# CITY OF MERCER ISLAND

RE: Request for Information #1 for File No. SUB21-006, CAO21-004, SEP21-022 – Milestone Short Subdivision  
7621 SE 22<sup>nd</sup> ST, Mercer Island, WA 98040; King County Tax Parcel # 531510-1846

The City of Mercer Island received the resubmittal for SUB21-006 on September 1, 2021 addressing the Incompleteness Letter dated 7/20/2021. In addition, the City of Mercer Island received the submittal for a Critical Areas Review 2 (CAR2) application and SEPA Review application on September 1, 2021. The CAR2 application was assigned application #CAO21-004 and the SEPA Review application was assigned #SEP21-022. The applications were determined to be complete on October 21, 2021. Following review of the applications listed above, City staff has determined that additional information is necessary to ensure compliance with the Mercer Island City Code (MICC). Please note that further review of this application is on hold until the following information is provided by the applicant (application status is "WCI" Waiting Customer Information). Please provide the following items:

MILESTONE PRELIMINARY SHORT PLAT

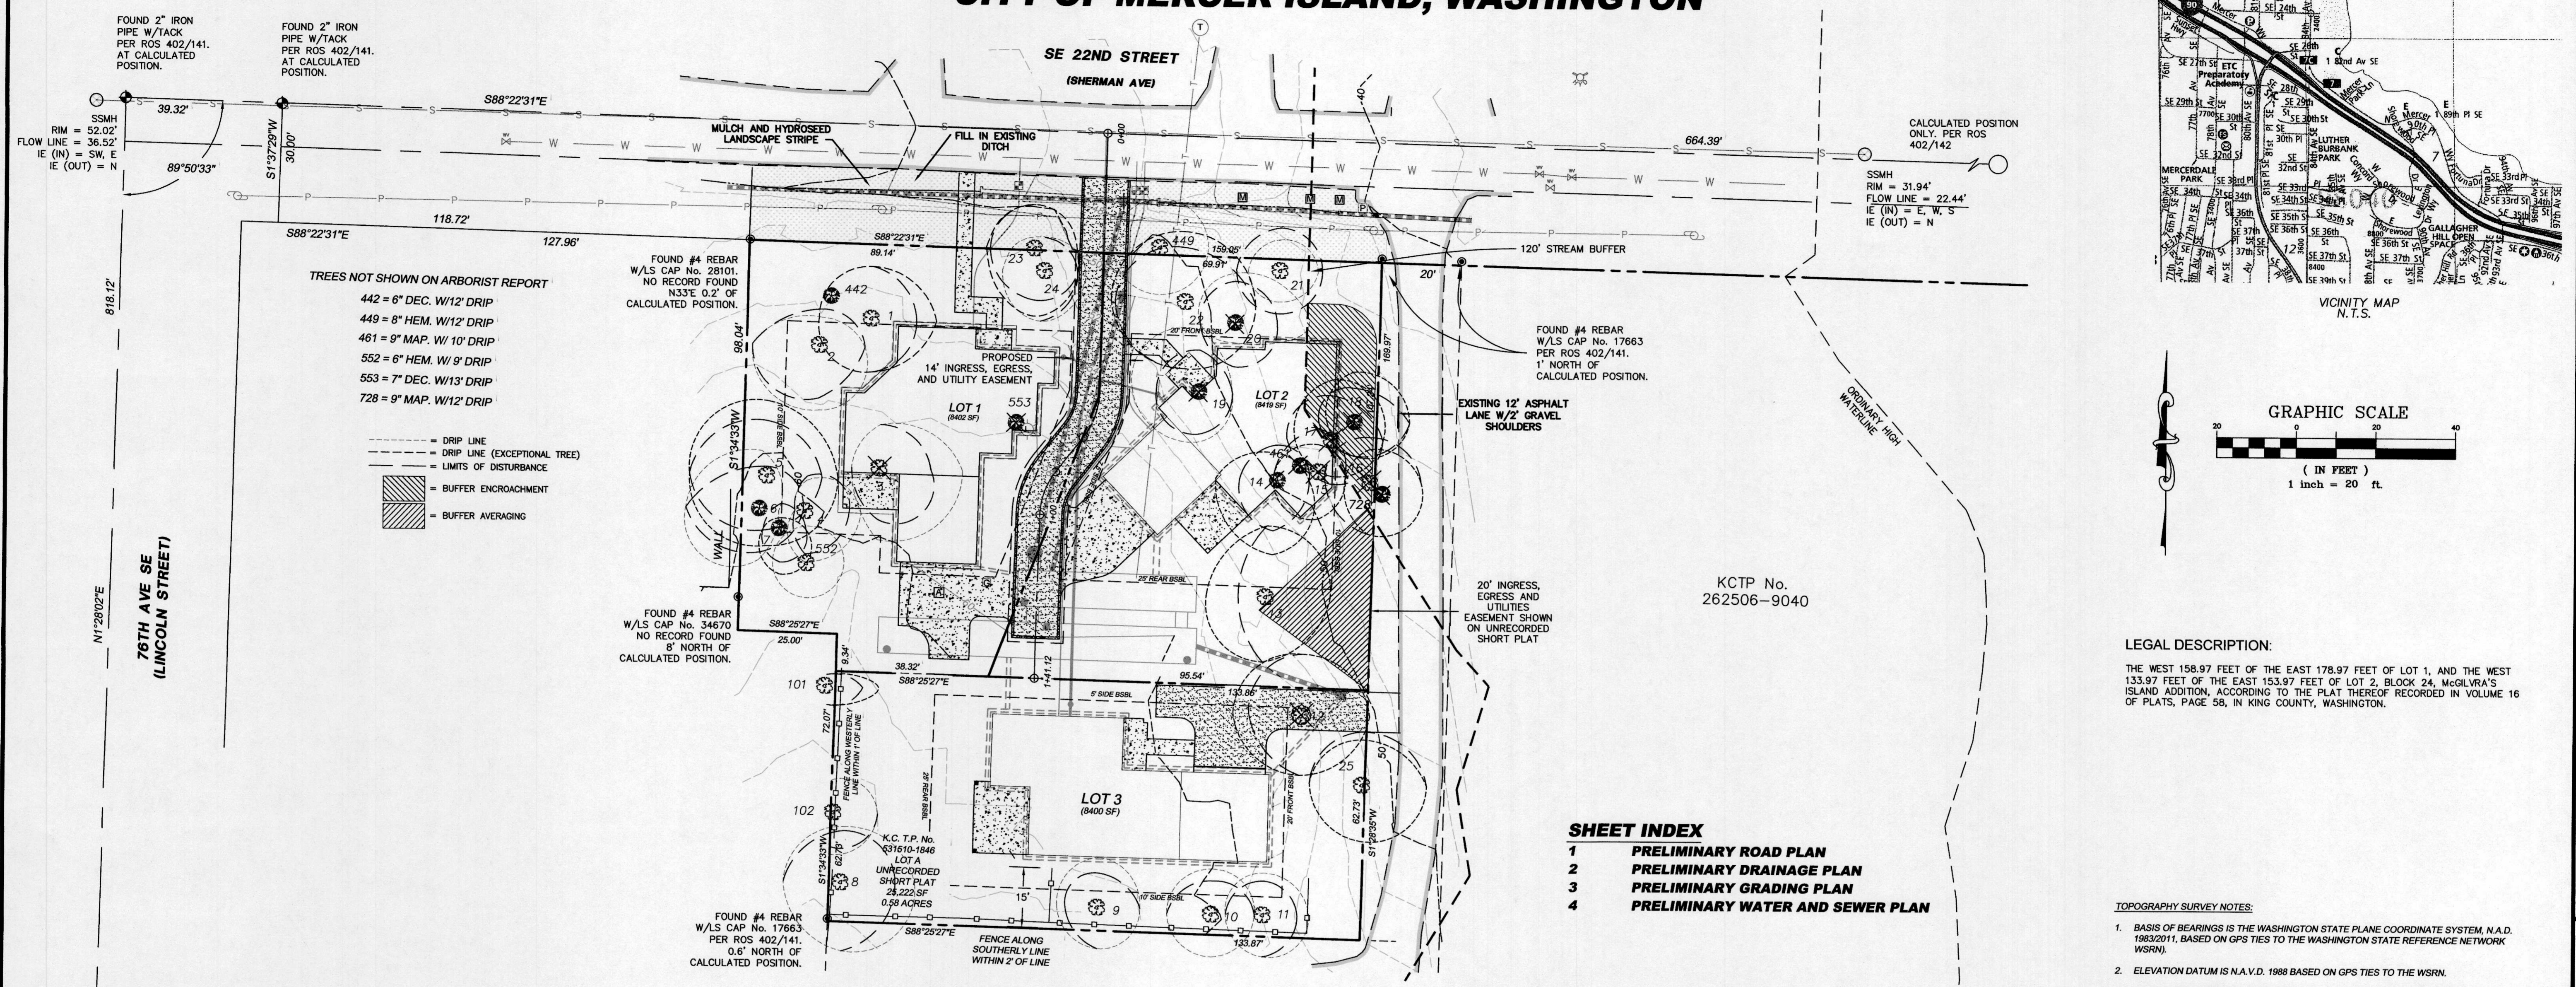
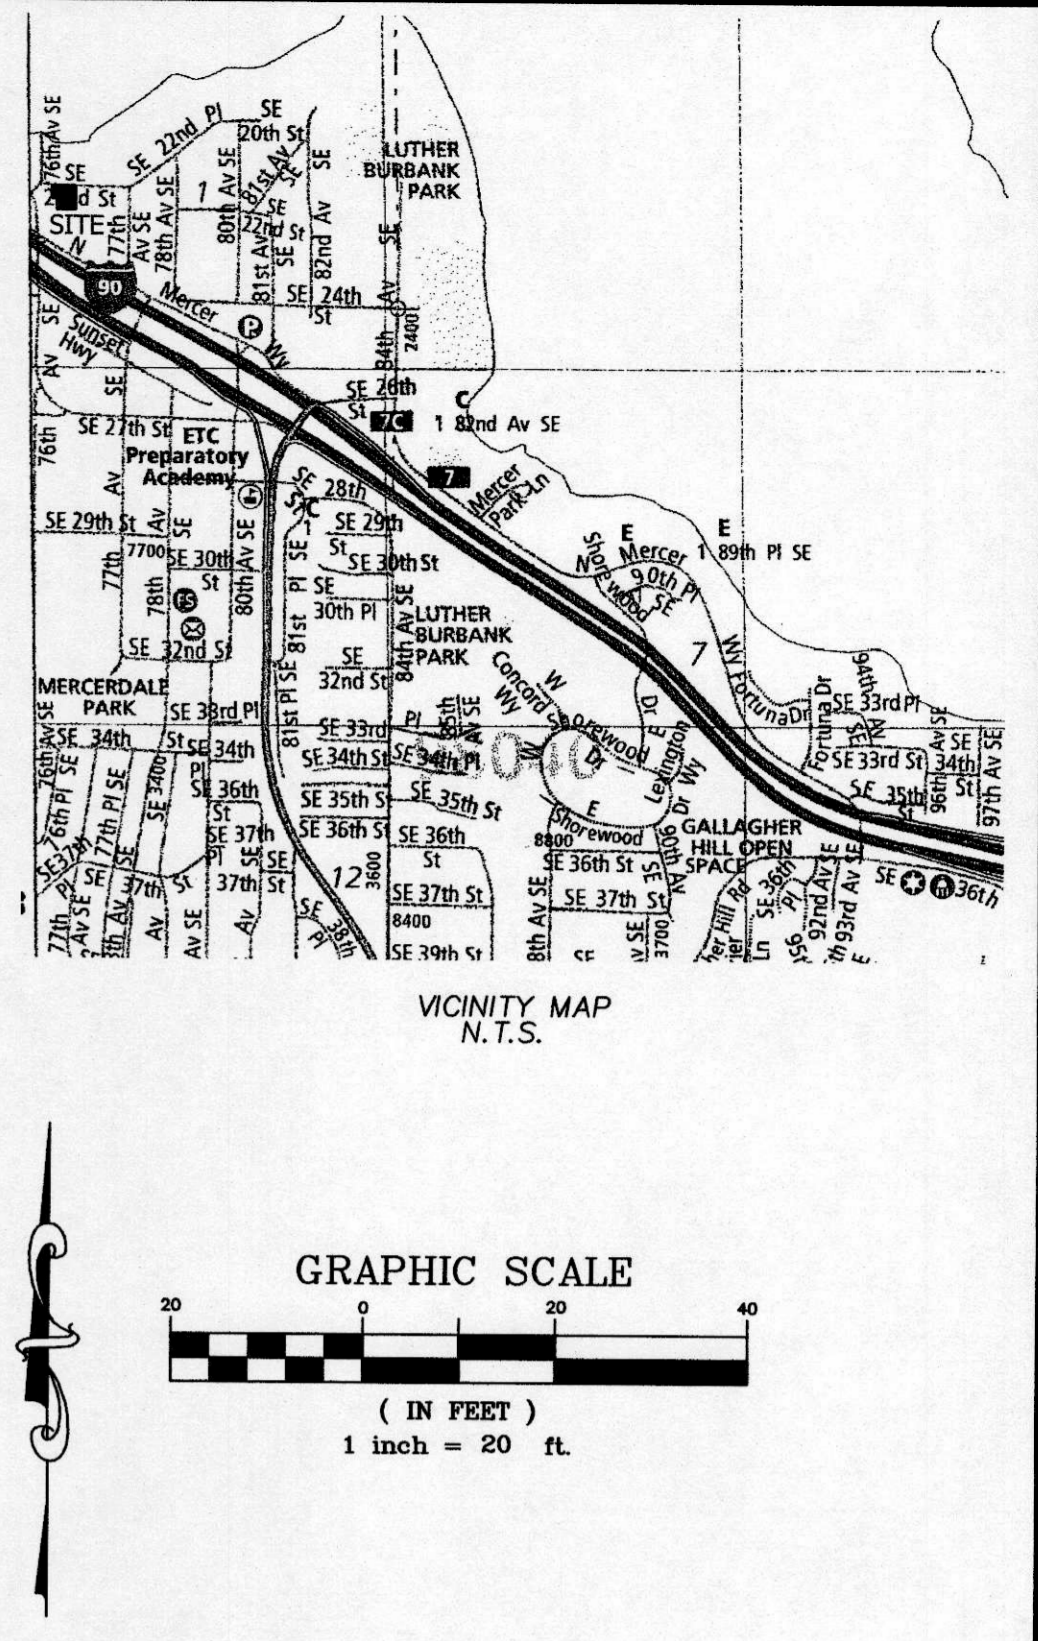
- iii. Please illustrate King County’s sewer on the sewer plan and include a profile view of the proposed sewer connection. Label the size of the sewer shown on the plans.

- iv. Please confirm if the proposed connection to the 8” local sewer.
